Recommendation Report for Planning Permission for Works or Extension to a Dwelling

REF NO: AW/238/20/HH

LOCATION: 10 Westminster Drive
Aldwick
PO21 3RA

PROPOSAL: Removal of lounge window, installation of new door and ramp to provide disabled access

Drawing Title: HT/04/Westminsterdrive10

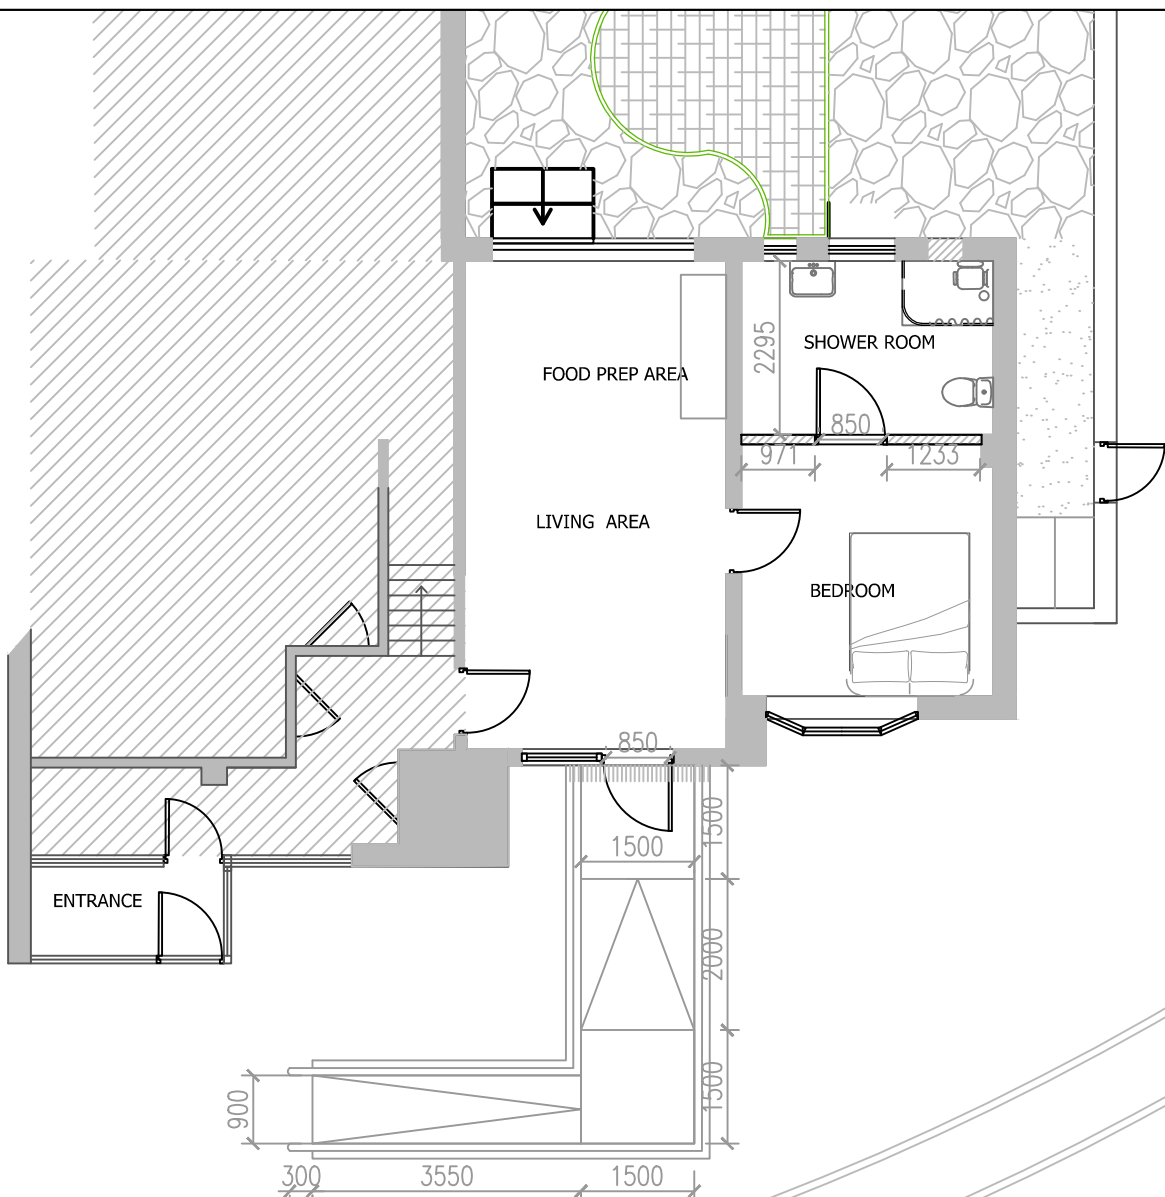
The installation of a new door and ramp to the property will sit at the front elevation. The concrete ramp will be constructed with a brick upstand to match the existing brick house with kee klamp railings.

The proposed ramp will measure at 900mm in height with the mid rail at 450mm, the rail will extend 300mm and return to the mid rail from the bottom of the ramp.

The construction of a front door to the front elevation will be UPVC with a level threshold and a side window to the left to match existing styles within the street.

The proposed height of the door is 1.8m high and has a width of 1.04m. The side window will have a proposed height of 1.45m and width of 0.96m. The rear end of the window will sit 0.4m to the bottom of the door, leaving a considerable space.

The front entrance door is to the North West of the property and as such the ramp runs along the North West elevation and is visible from the street scene. There is not currently an existing ramp in use, the length of the ramp will be 5.68m and will have a maximum height of 1.41m.

Whilst the ramp extends beyond the principle elevation, the height is modest and with sufficient separation to the neighbouring property, it is not considered to result in adverse impacts upon the residential amenity.
